April 14, 2026

Kittitas County Community Development Services

**RE: SEPA Environmental Checklist — Application SE-26-00003 Kittitas PUD #1
Headquarters, 4271 Kittitas Hwy, Parcel 051833 Formal Comment and Request for
Determination of Significance**

COVER SHEET & OVERALL
SITE LAYOUT

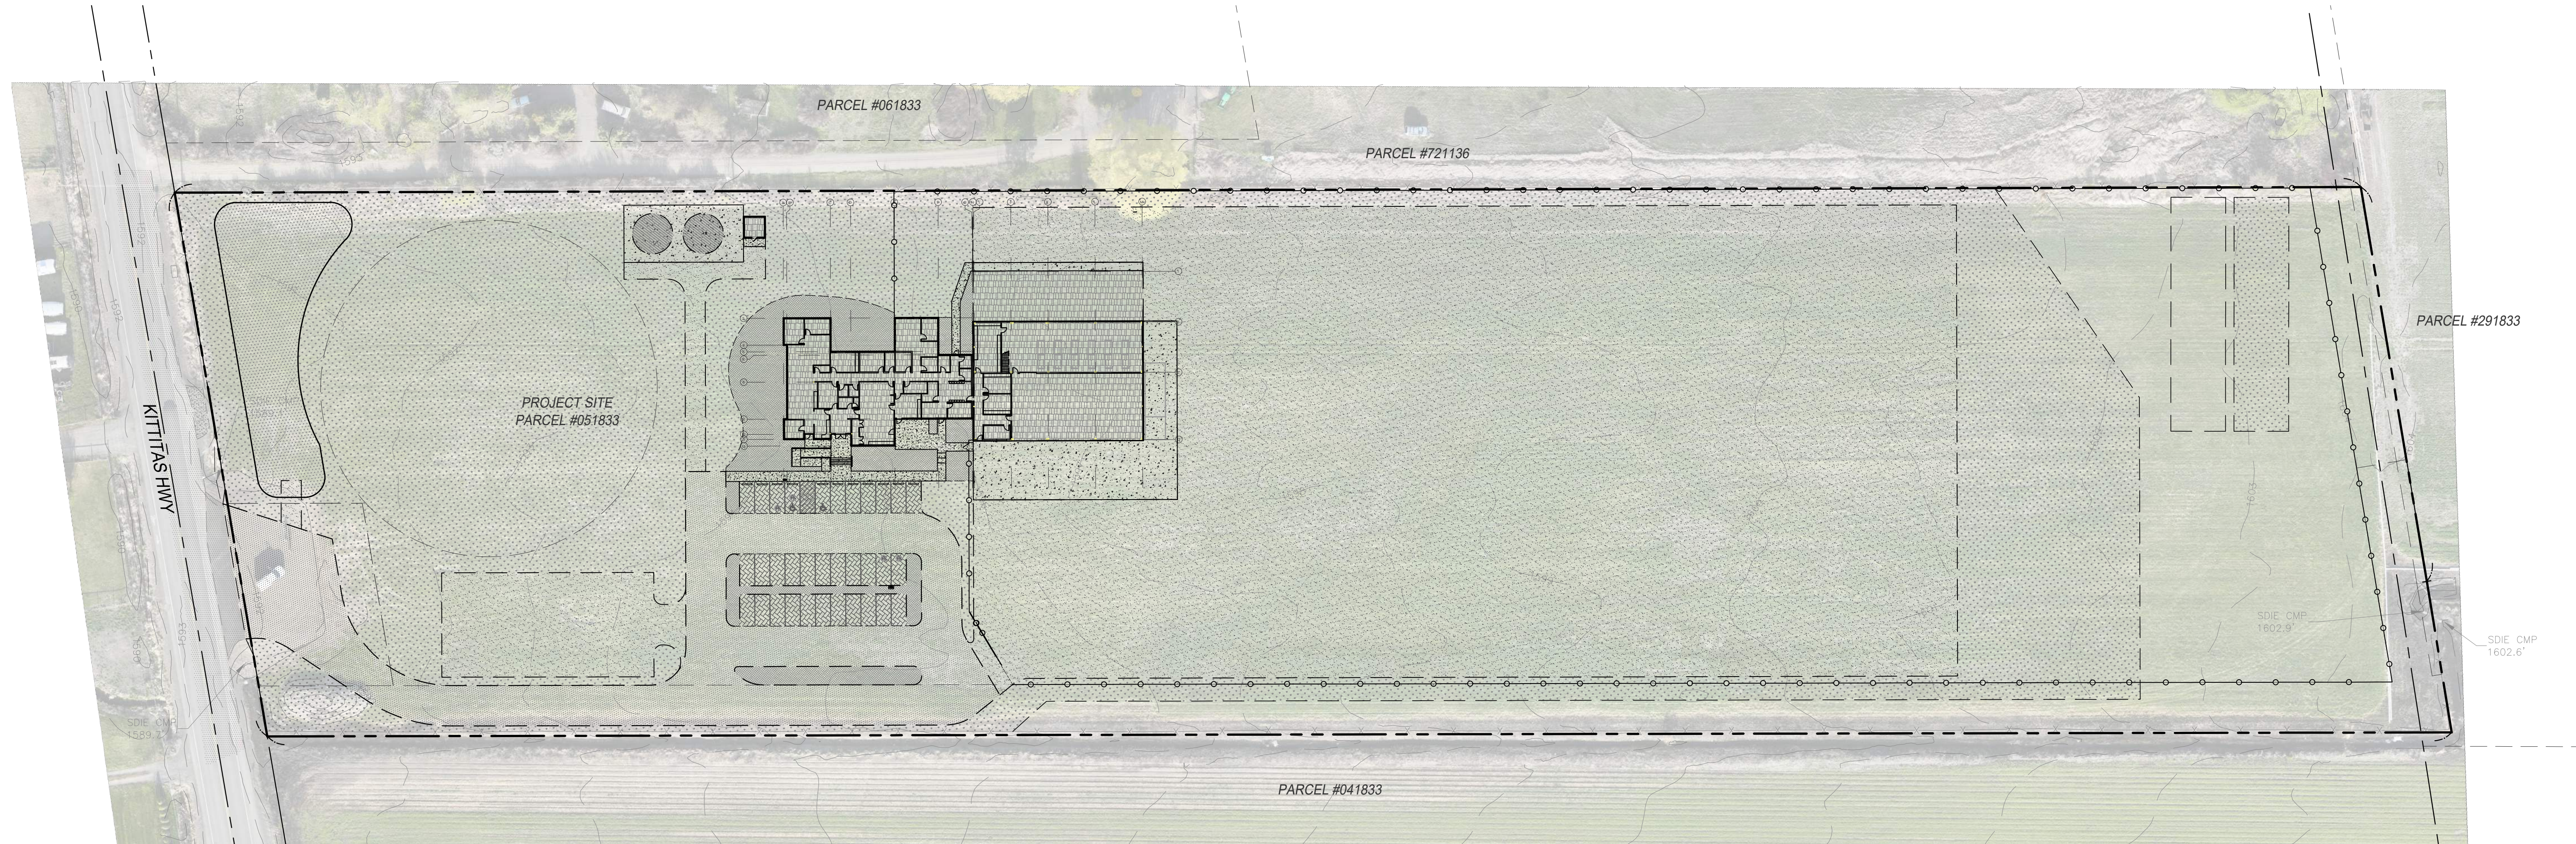
4. Stormwater — Inadequate Analysis for 53.5% Impervious Cover Conversion

The applicant discloses that approximately 53.5% of the 9.65-acre site will be covered with impervious surfaces after construction. This represents conversion of more than five acres of previously permeable agricultural land to impervious cover, a major hydrological change.

The sole proposed mitigation described is 'swales and a detention pond with natural filtration.' No engineering calculations, detention pond sizing, downstream drainage analysis, or stormwater management plan has been submitted with this application. In a rural agricultural valley where adjacent landowners rely on established drainage patterns, this level of impervious cover conversion without a complete stormwater engineering report is insufficient.

The County should require a complete stormwater report prepared by a licensed engineer, including detention pond sizing calculations, downstream impact analysis, and documentation that the detention facility will adequately control discharge at the pre-development rate claimed by the applicant before any threshold determination is made.

OVERALL SITE PLAN

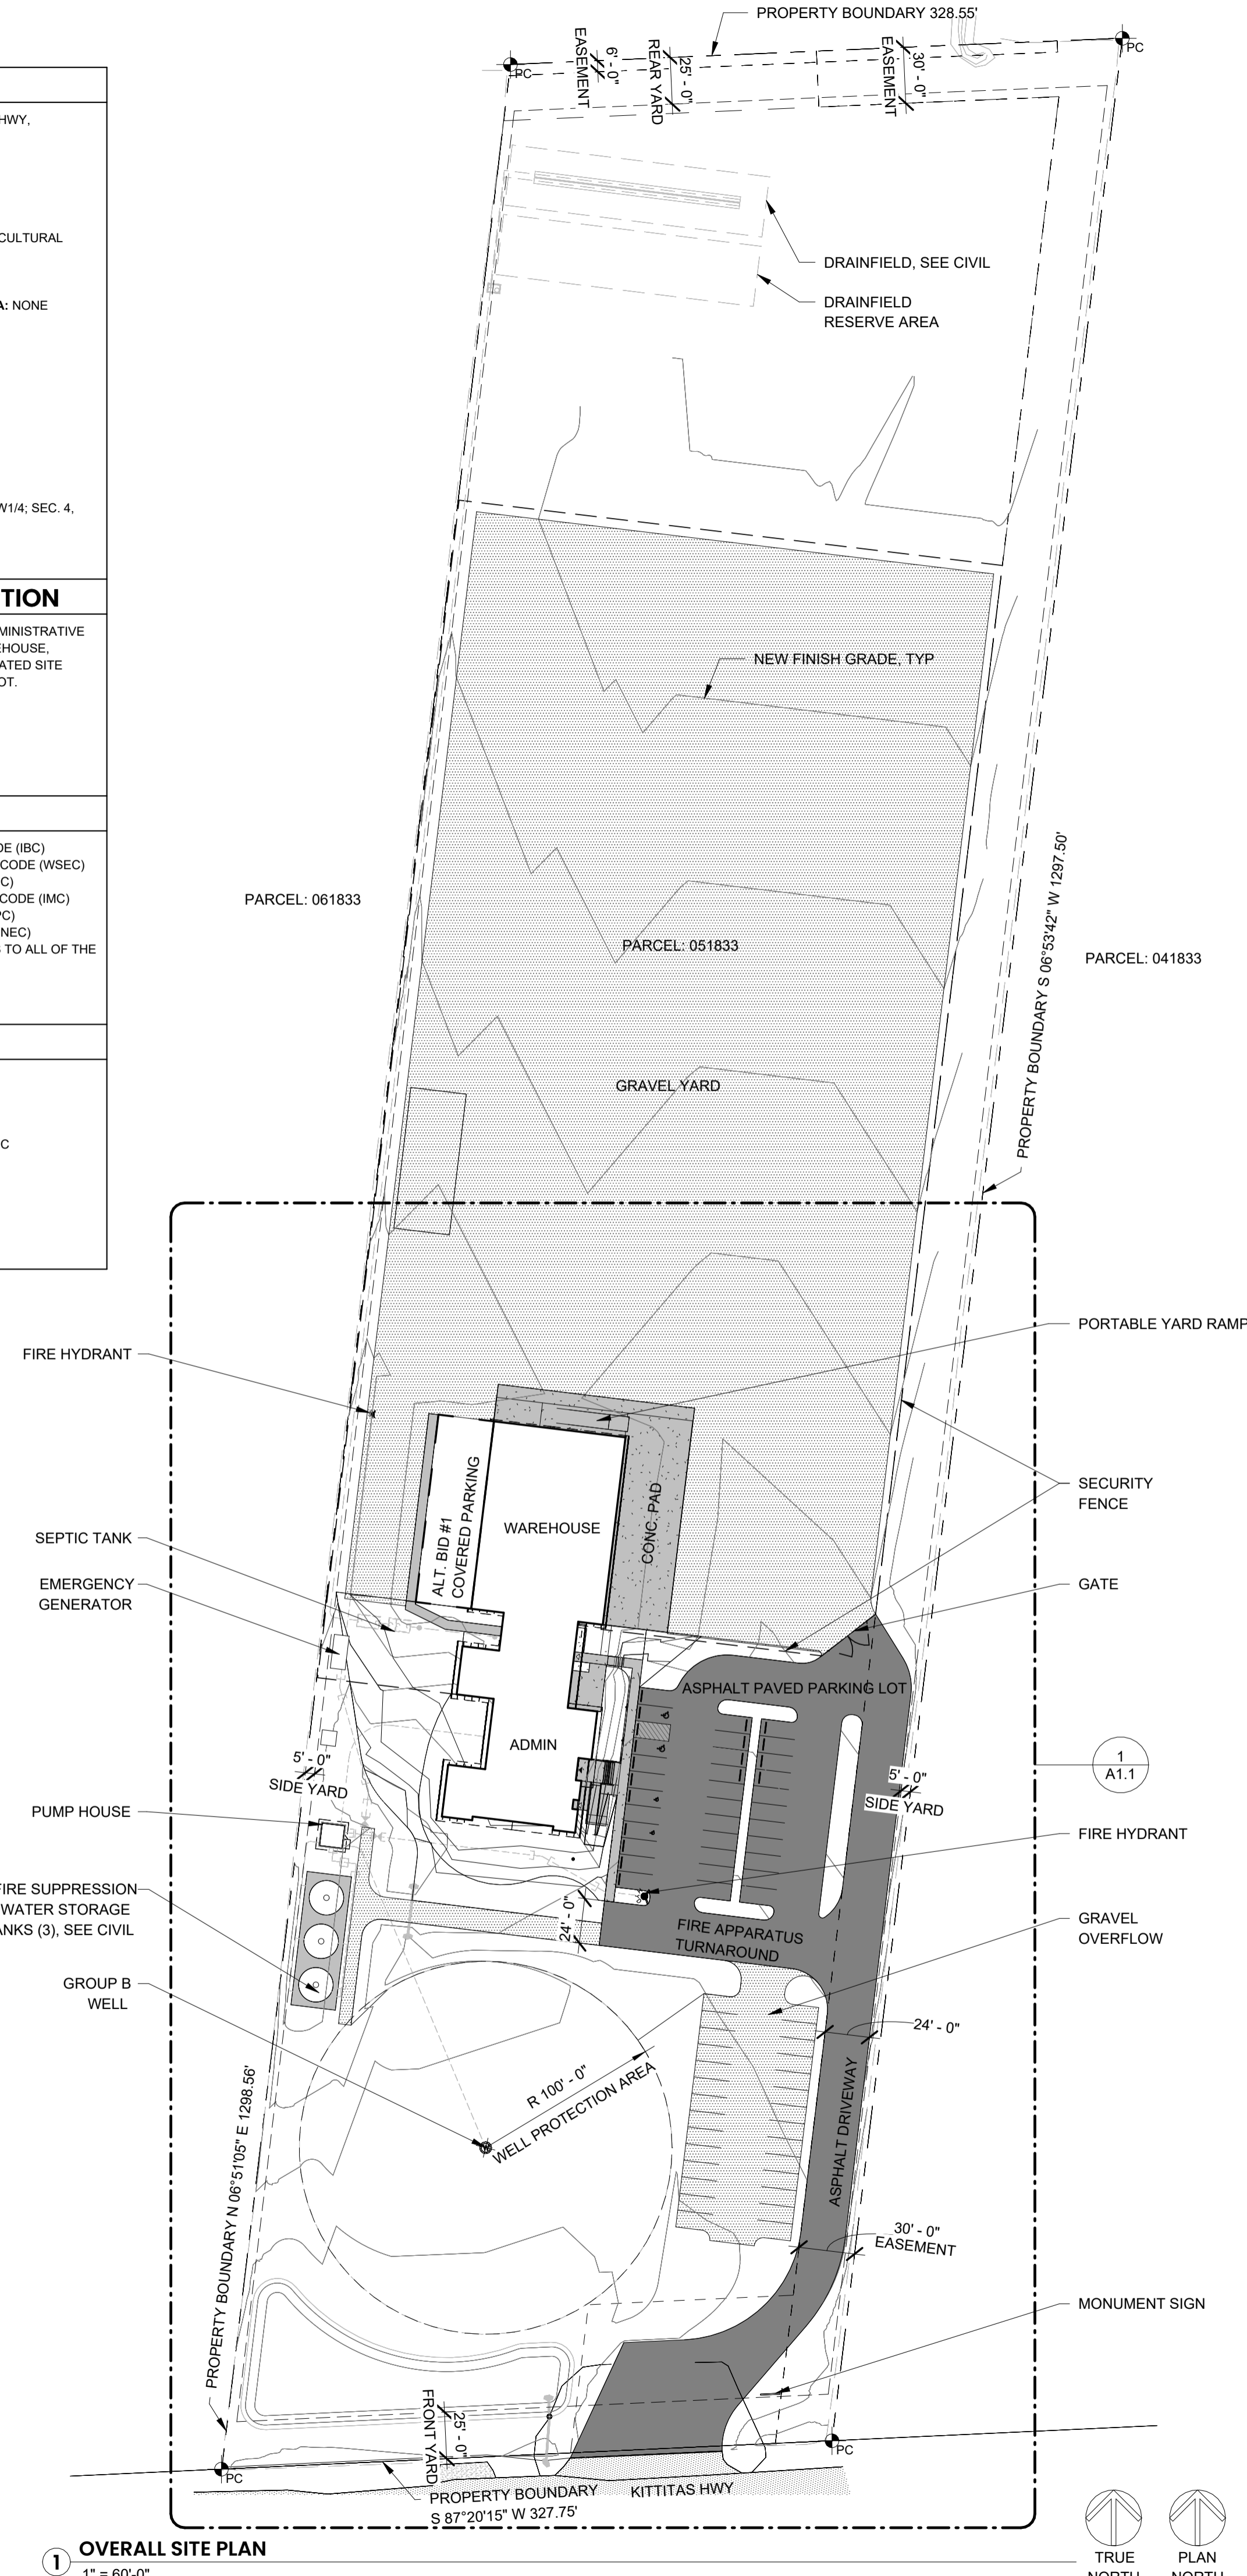
The checklist discloses that the subject parcel is zoned Agriculture 20 (A-20) with a comprehensive plan designation of Rural Working Land Use. The proposed project — a 10,200 square foot pre-engineered metal building, 6,300 square foot administration

building, material storage yard, pump house, and two 60,000-gallon water tanks — is a large commercial/industrial utility facility. This use does not conform to the A-20 zoning district on its face.

The checklist asserts on page 8 that 'the project is in keeping with the rural character of the site and surrounding area, in compliance with all applicable County and State codes,' but provides no analysis, citation to applicable zoning code provisions, or explanation of how a utility headquarters satisfies A-20 use requirements. The County must require the applicant to specifically identify the zoning code provision under which this use is permitted outright, or acknowledge that a Conditional Use Permit (CUP) is required and initiate that process. The failure to address this fundamental land use compatibility issue is a material omission in the checklist.
